PROJECT
**HYDROLOGIC &
HYDRAULIC ASSESSMENT
ALTITUDE ASPIRE
TERRANORA ROAD
TERRANORA
NEW SOUTH WALES**

PREPARED FOR
NEWLAND DEVELOPERS PTY LTD

DATE
APRIL 2013

This report constitutes a revision of the HHA in response to comments received from TSC and (DOPI) regarding the Draft PPR, and is written in support of the Revised PPR application.

DRAWING NO
207

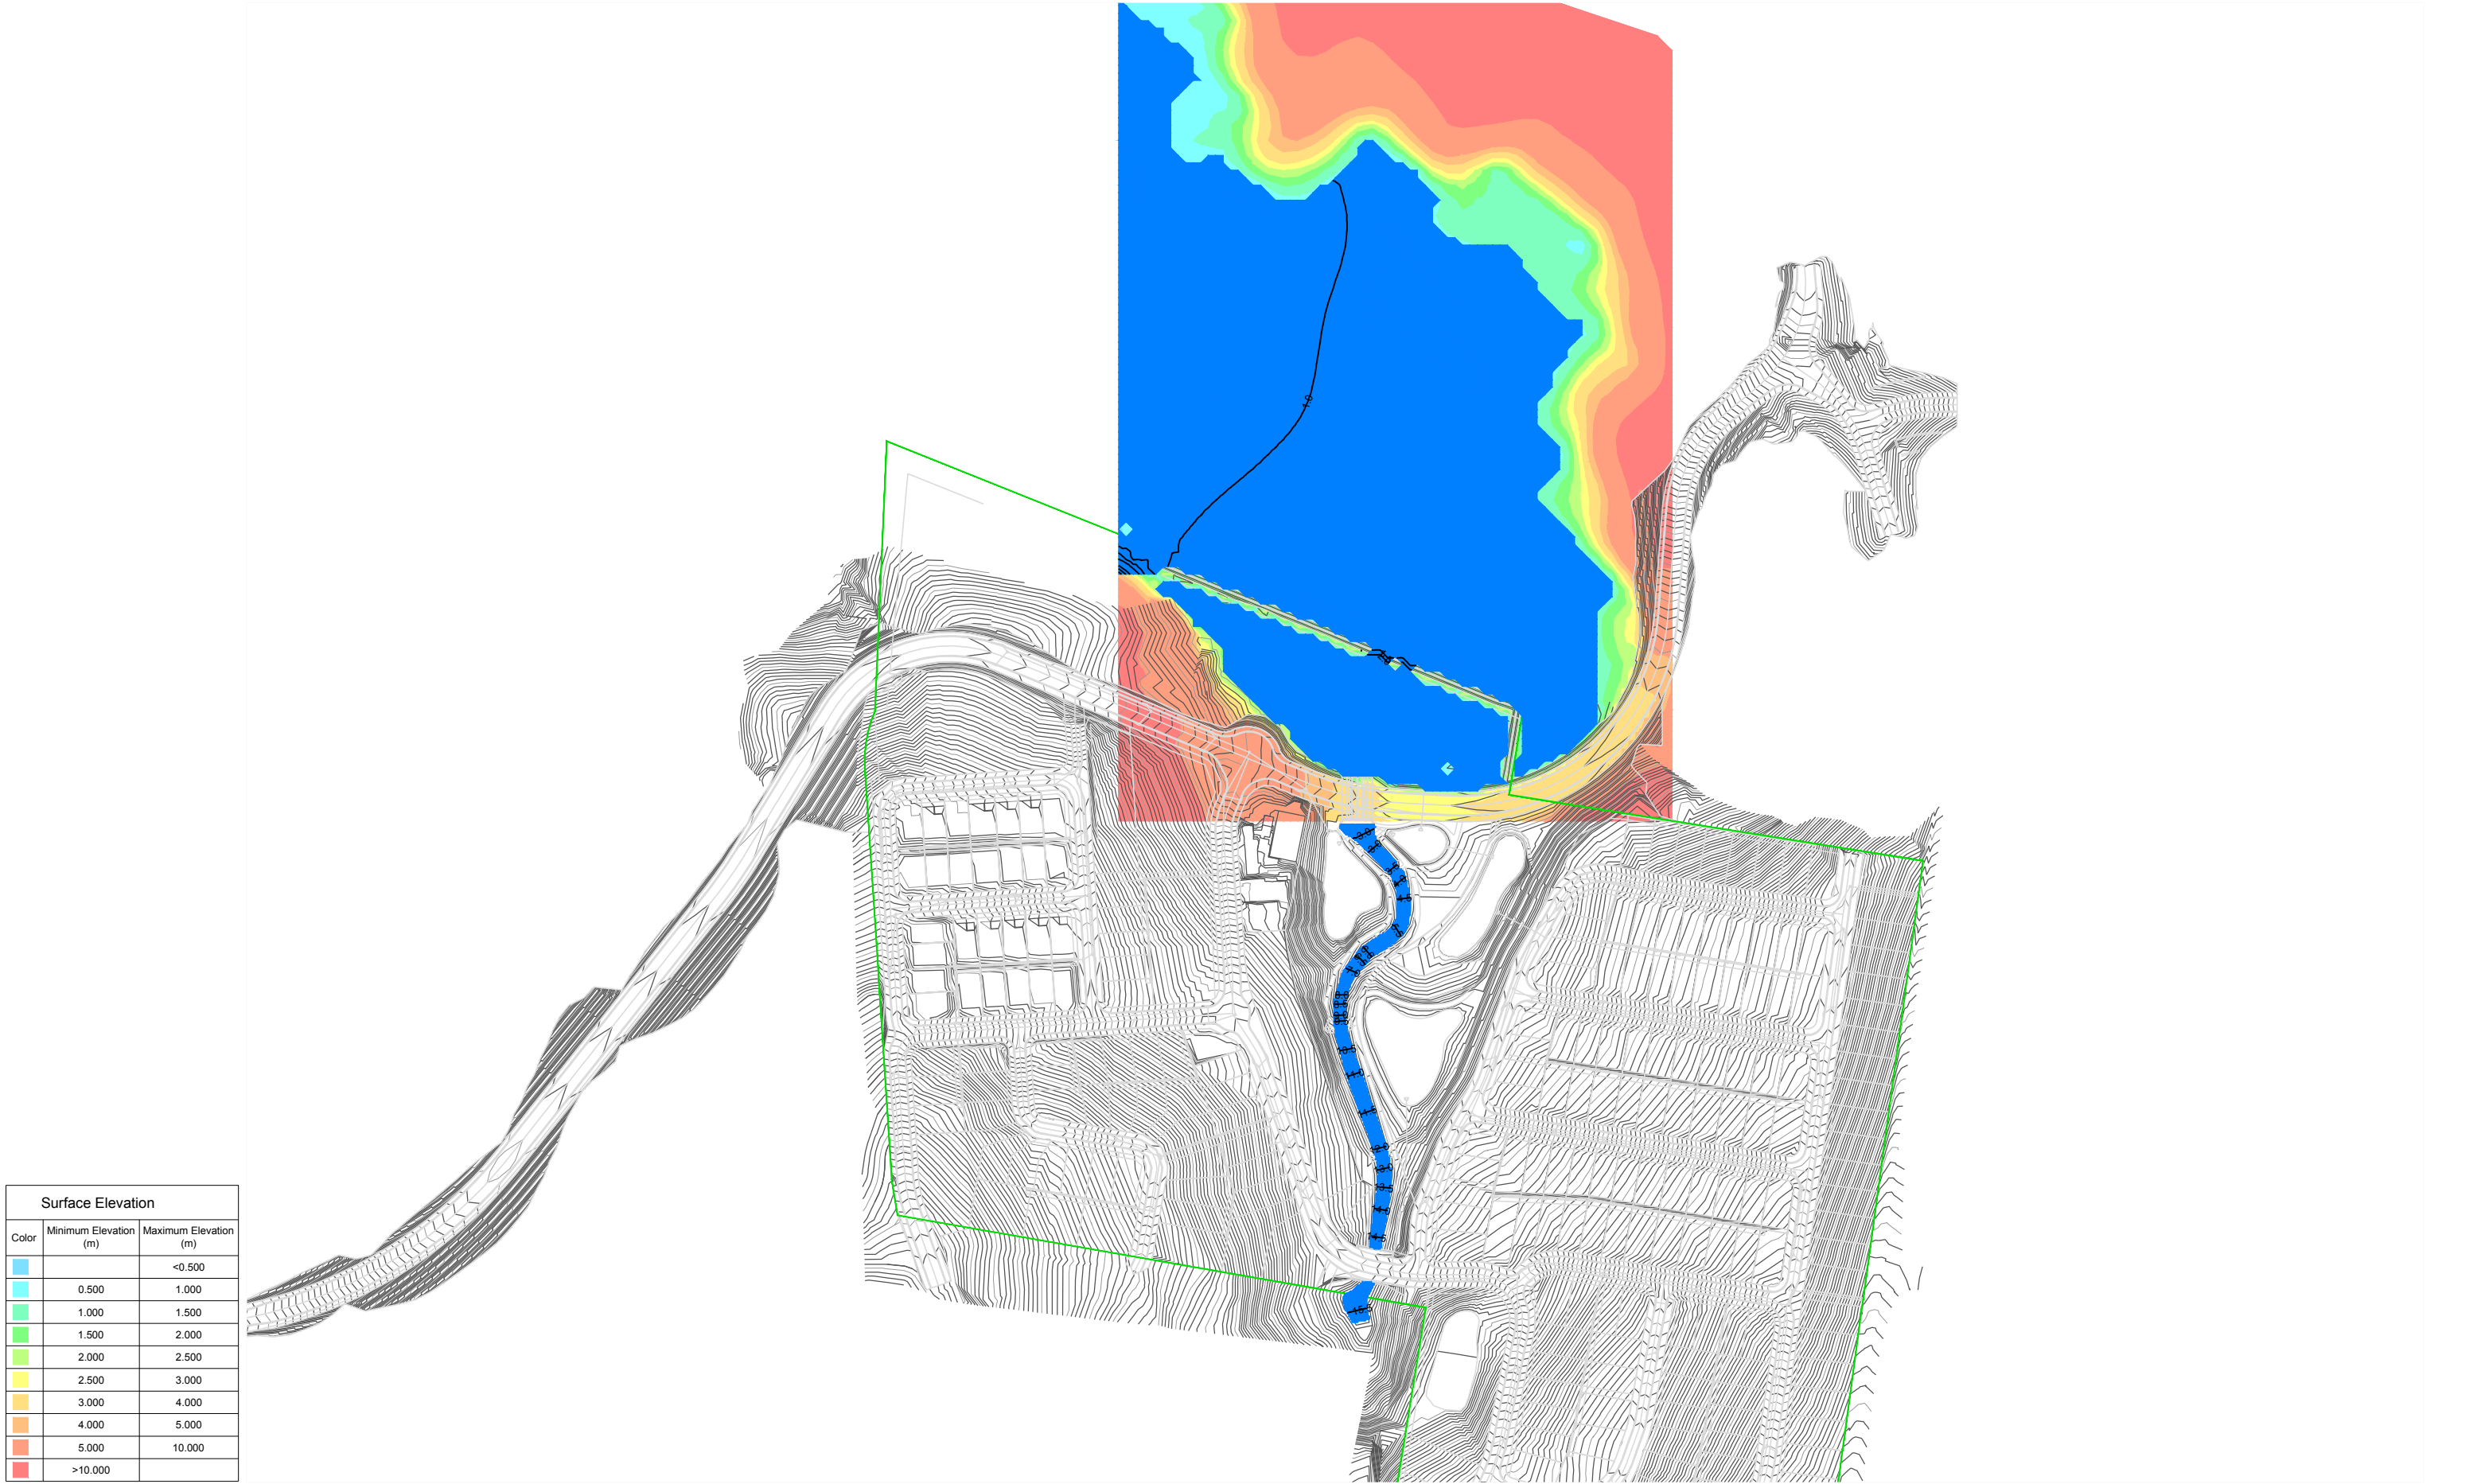
ii. Drawing 207 - which should have details on the stormwater channel road crossing, as referenced on page 15.

c) Errors/Mis-descriptions in the Hydrologic & Hydraulic Assessment Report – there are some aspects of the HH Report which requirement amendment, including the report missing ‘section 5.3’, which should have design information on the “detention device” as referenced on page 13 and Drawing 207 should have details on the stormwater channel road crossing as referenced on Page 15. These details need to be provided.

Noted. The typographical error (having labelled two different drawings with the same drawing number) has been rectified.
